Our Ref: BE/75/19/HH
Your Ref:

Town & Country Planning Act 1990 (as amended)
Town & Country Planning (Development Management Procedure) (England) Order 2015
Application for Planning Permission for Works or Extension to a Dwelling

Development Loft conversion to form new 2nd floor with front dormer projection.
Location 5 Finch Gardens Bersted

sheet 1 of 3

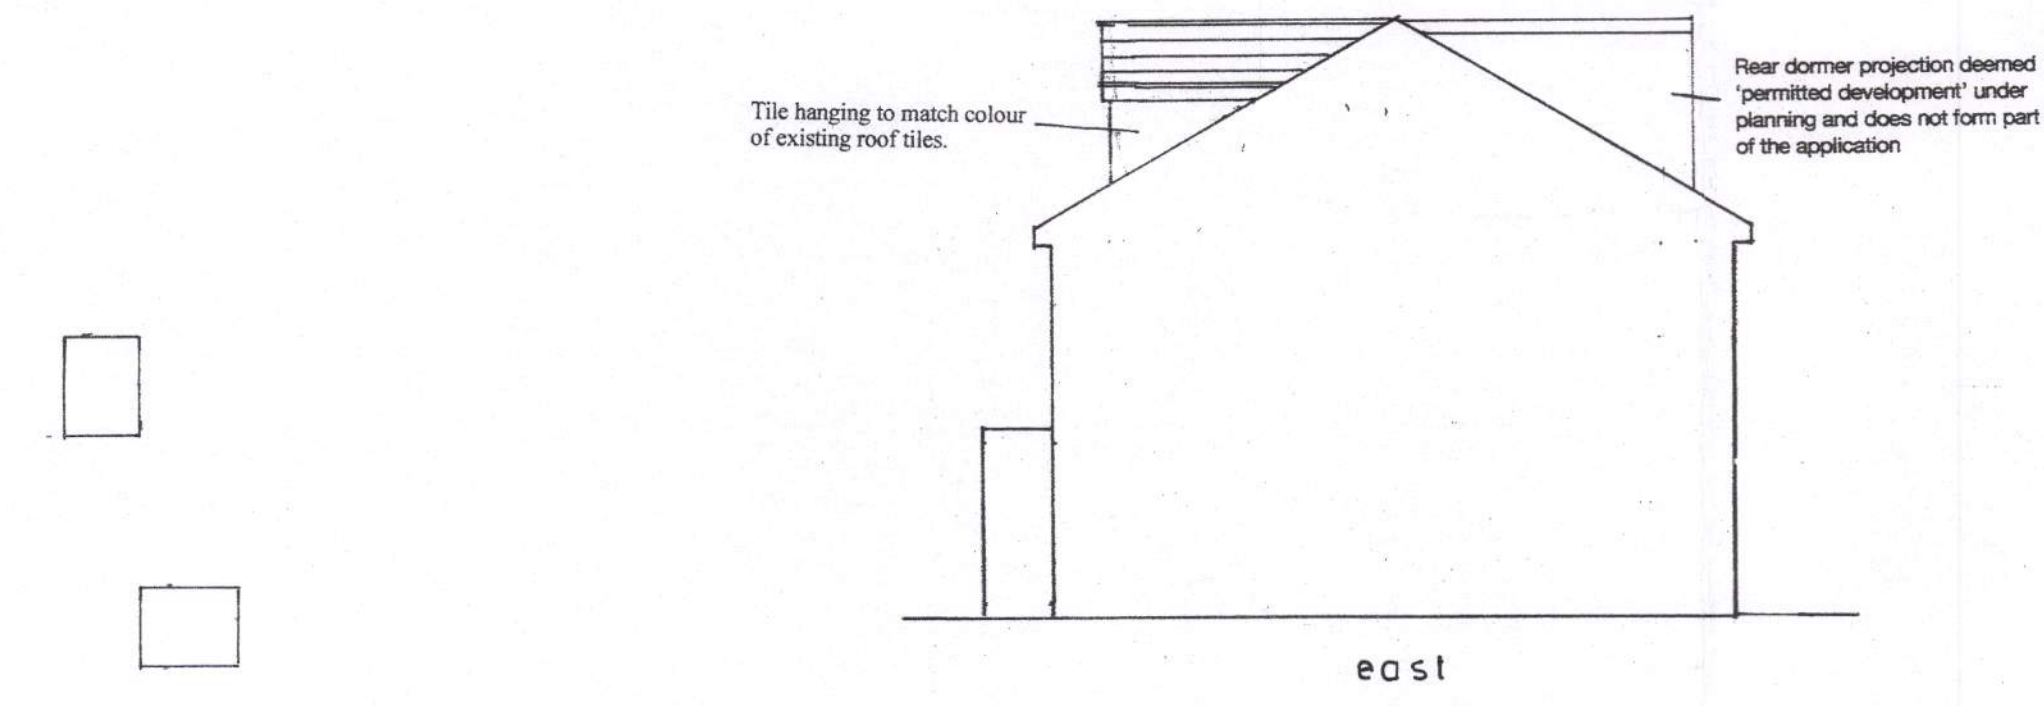
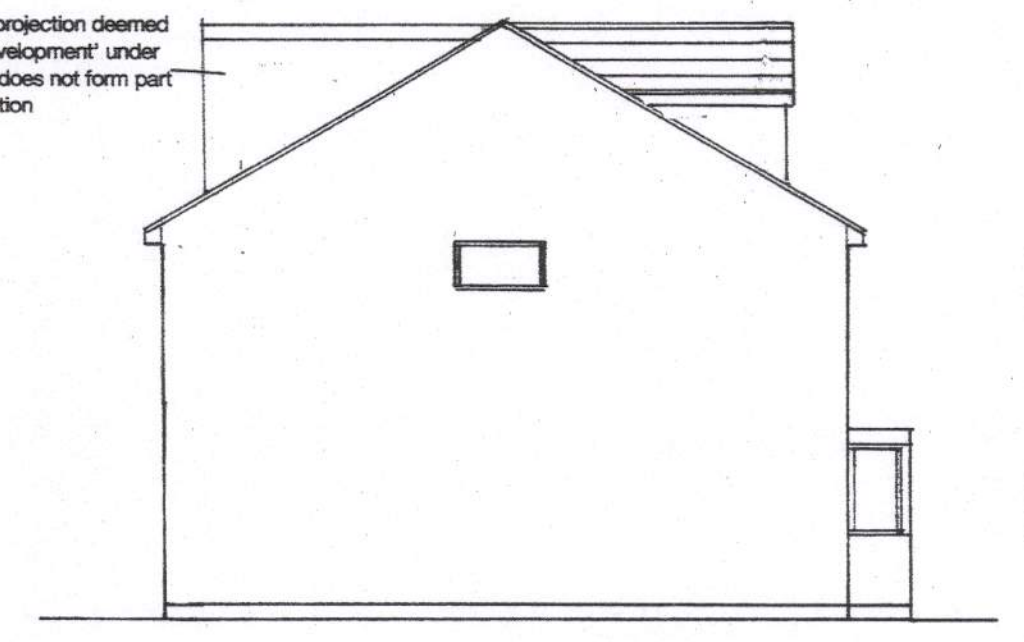
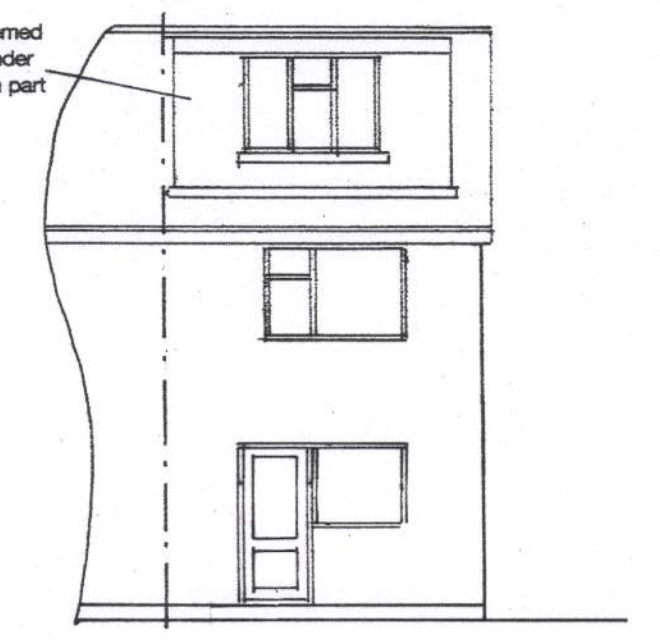
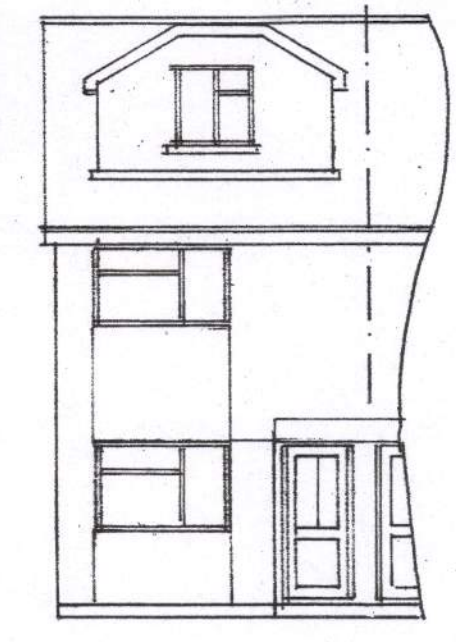
Permitted Development: As the proposal is for a loft conversion you will either need to include the rear dormer as part of this proposal instead of a permitted development or remove the rear dormer from all plans associated with this proposal and submit the permitted development at a latter date. Please confirm which direction you would like to take with the application and amend accordingly.
